DRB Application No.: <u>07DRB-00557 (SBP)</u>	Project # <u>1004997</u>
Project Name: <u>TOWER WEST SUBDIVISION</u>	
Agent: <u>Mullen Heller Architects</u>	Phone No.: <u>268-4144</u>

6. **Project # 1004997**
07DRB-00557 Minor-SiteDev Plan
BldPermit/EPC
- MULLEN HELLER ARCHITECTURE agent(s) for 98TH TOWER JACK LLC request(s) the above action(s) for all or any portion of Lot(s) B-1-A, **TOWER WEST SUBDIVISION**, zoned SU-1 for C-1 and R-2 uses, located on TOWER RD SW between 98TH ST SW and 97TH ST SW containing approximately 2 acre(s). [REF: 06EPC00952, 06EPC00953, 07EPC00105] [Catalina Lehner, EPC Case Planner] (L-9) **THE SITE PLAN FOR BUILDING PERMIT WAS APPROVED WITH FINAL SIGN OFF DELEGATED TO TRANSPORTATION DEVELOPMENT FOR THE CITY STANDARD WORK DRAWING NUMBERS, A WIDER CROSS- ACCESS- SIMILAR- TO- THE- PLAT- AND- PLANNING FOR CATALINA LEHNER'S INITIALS AND 3 COPIES OF THE PLAN.**

DATE: May 7, 2007
TO: Sheran Matson, DRB Chair
FROM: Catalina Lehner, Senior Planner *CL*
RE: Project #1004997, Tower/98th Building

project title  
**Proposed Retail Building**  
Southeast Corner of 98th Street and Tower Road  
Albuquerque, New Mexico  
sheet title  
**Exterior Elevations**

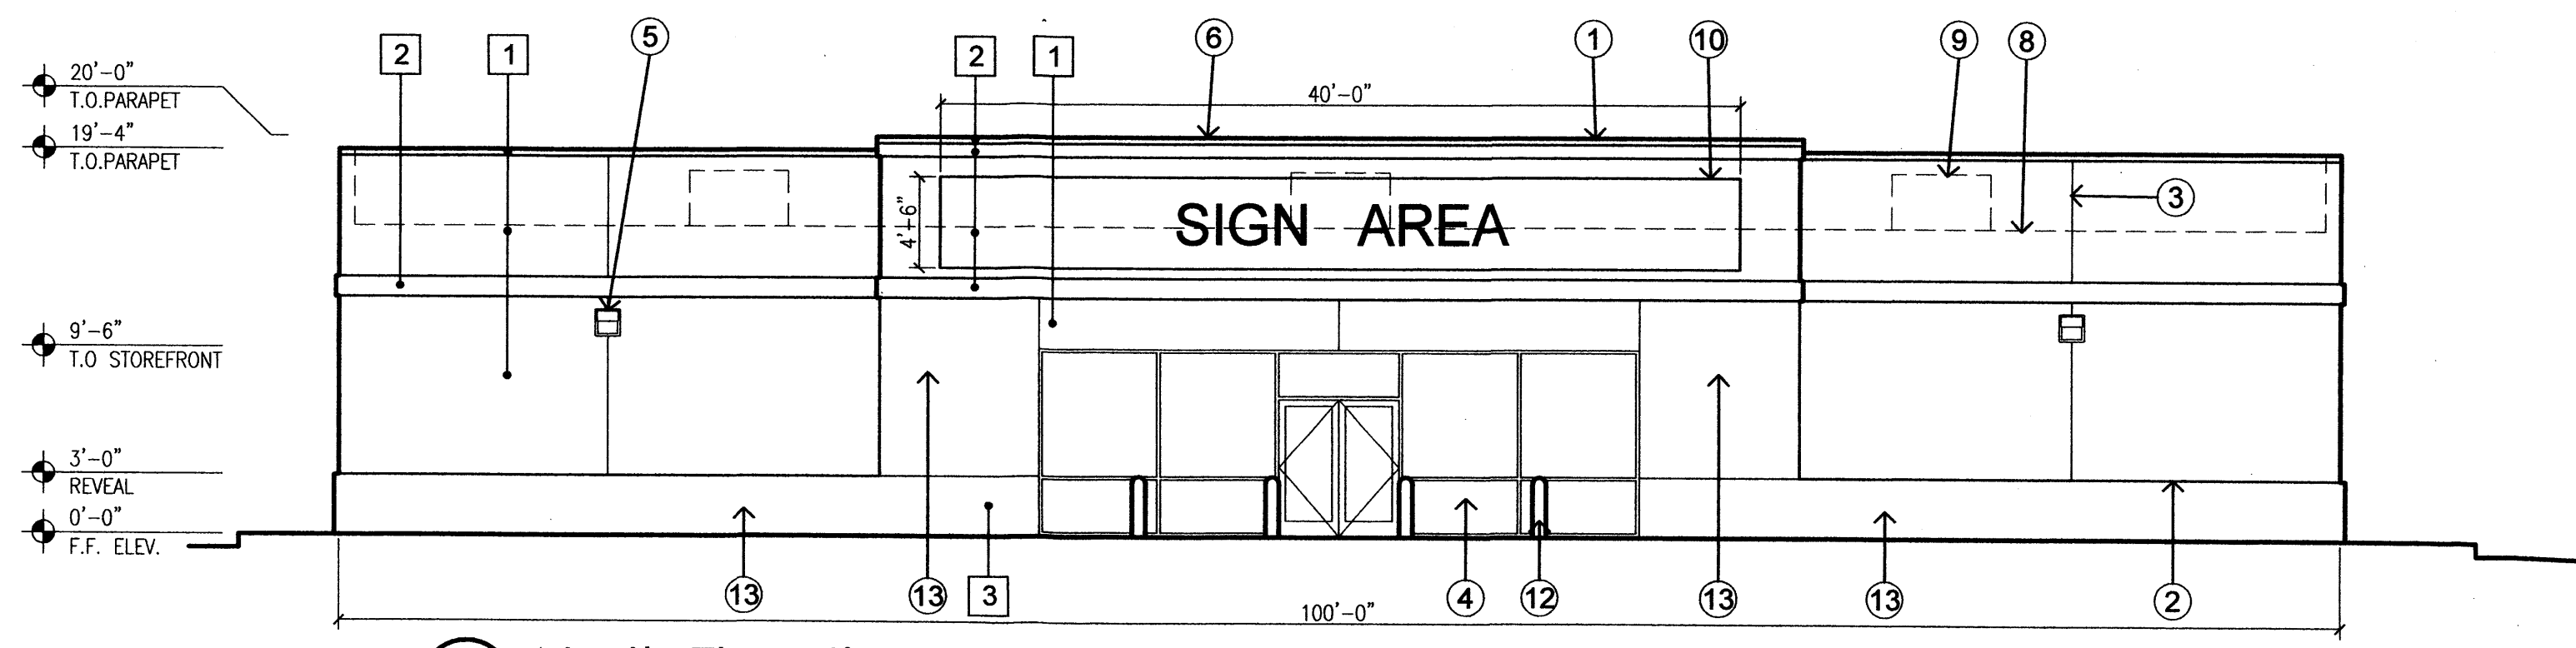
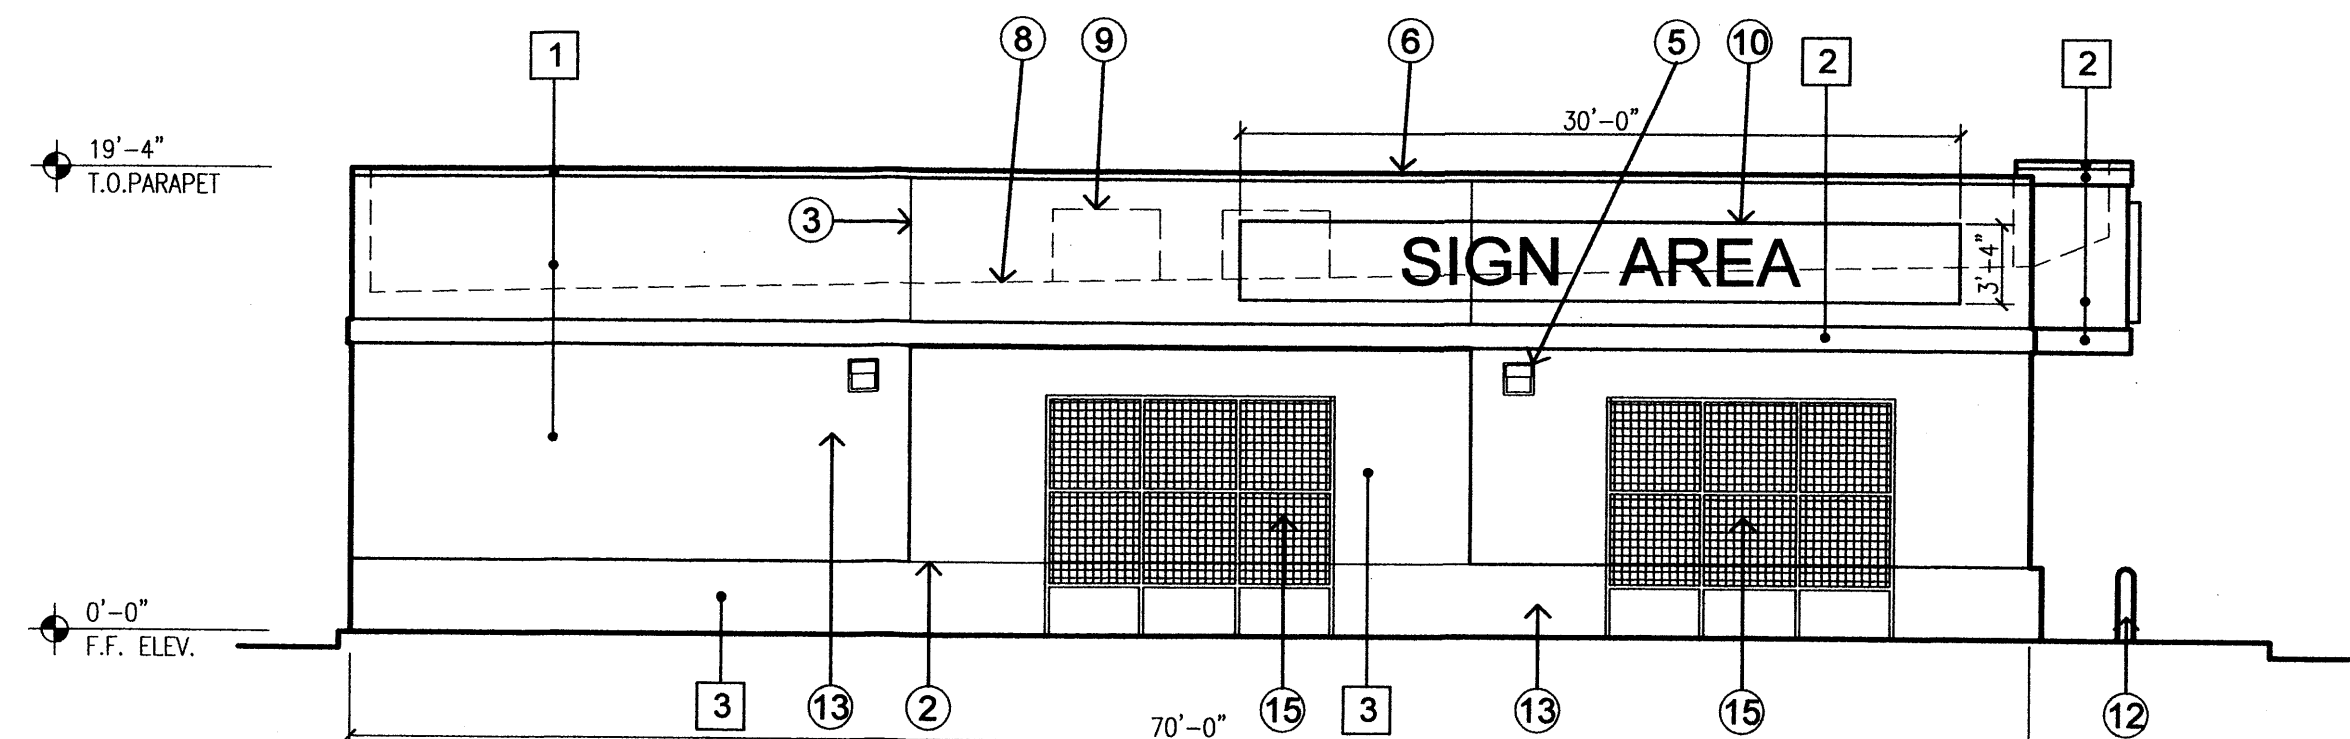
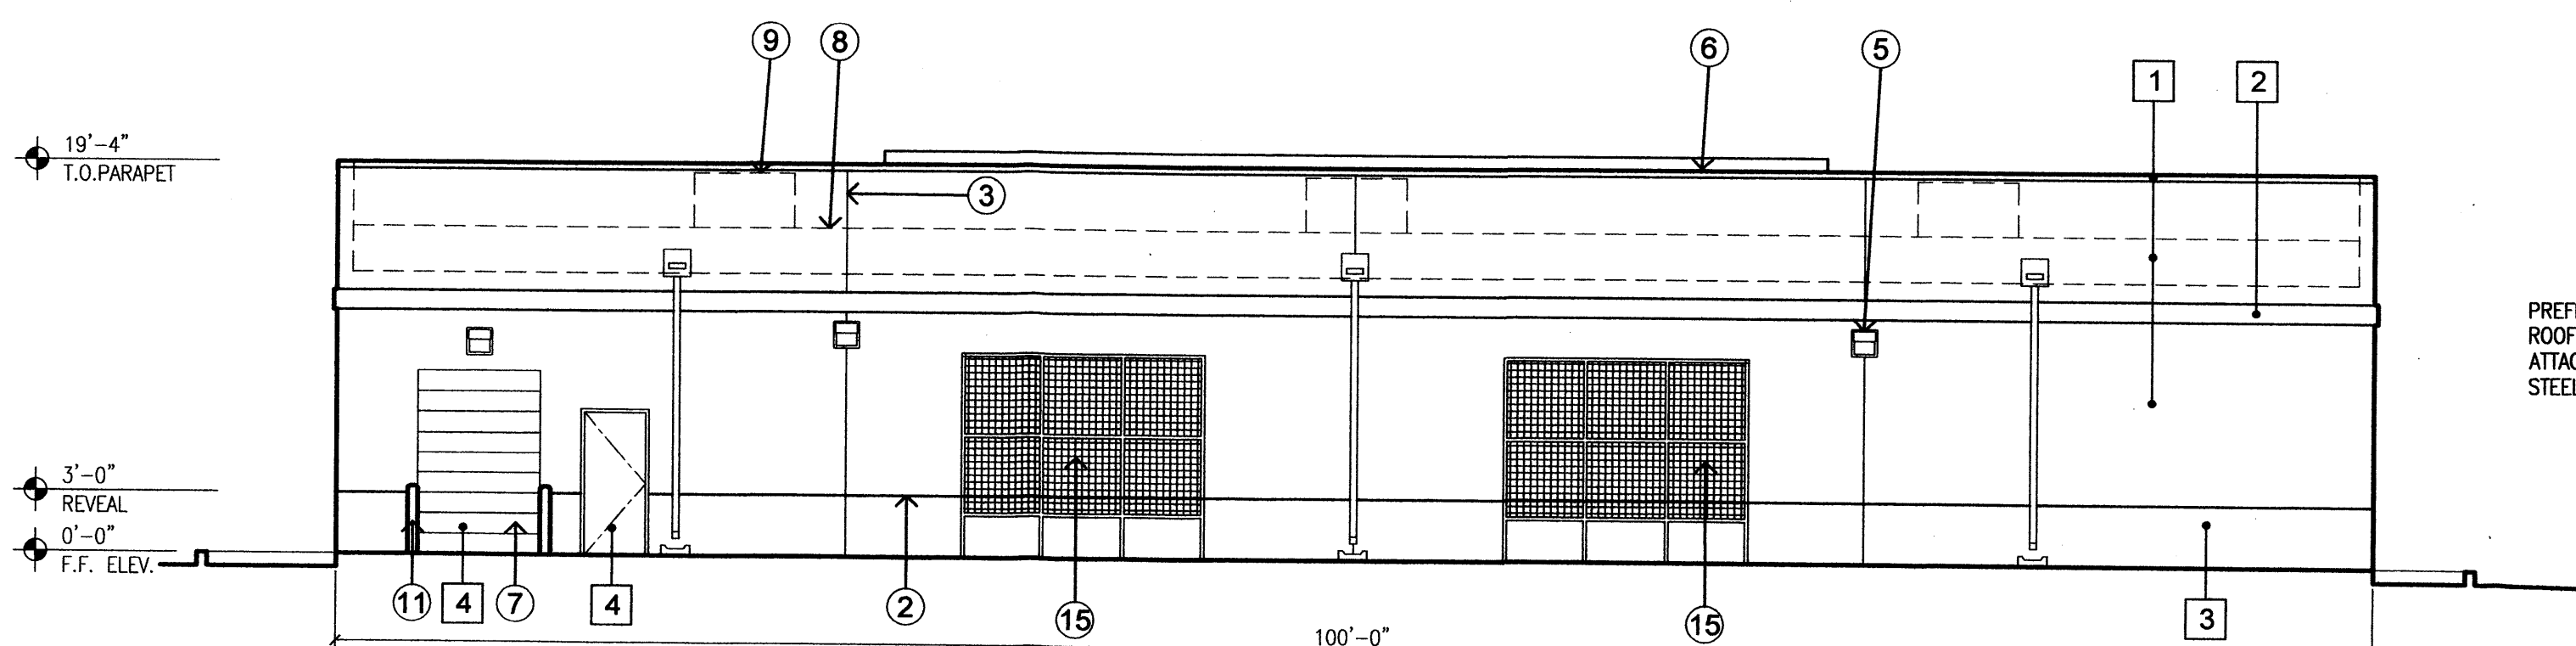
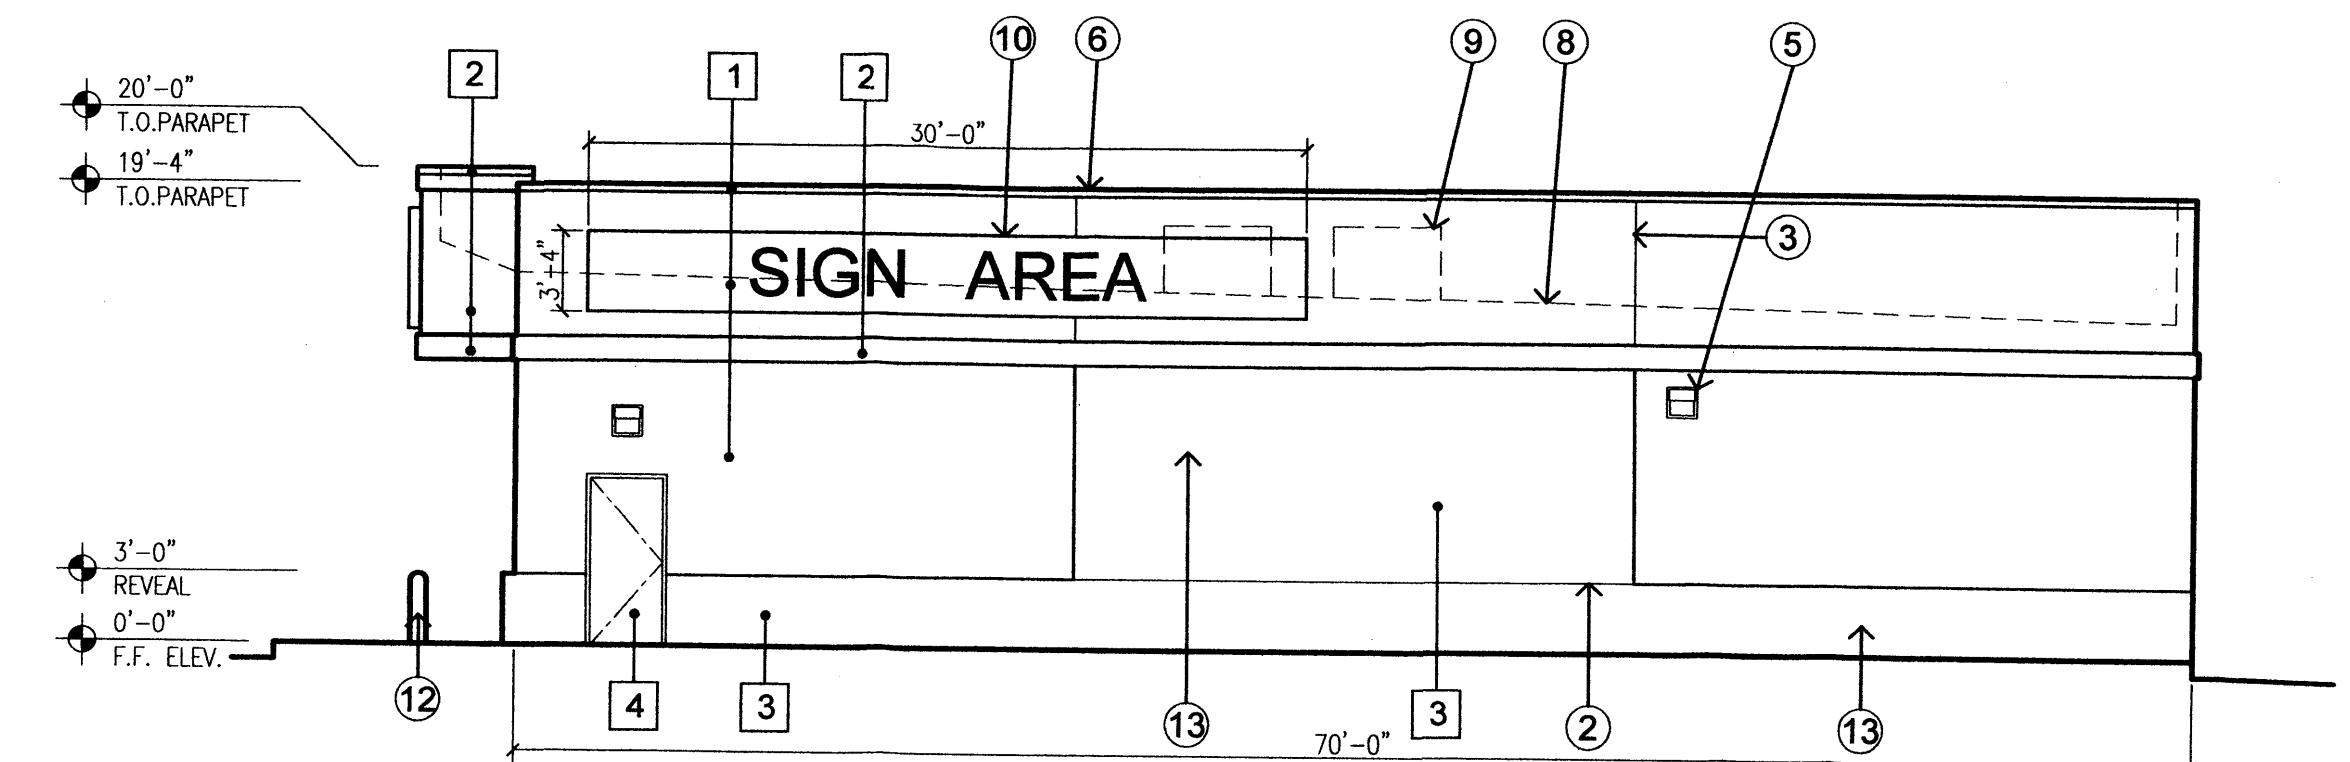
Condition 7A-Signage: A note shall be added to the elevations sheet indicating that building mounted signage shall be limited to approximately 7% of the façade for the northern elevation and approximately 6% of the façades for the eastern and western elevations.
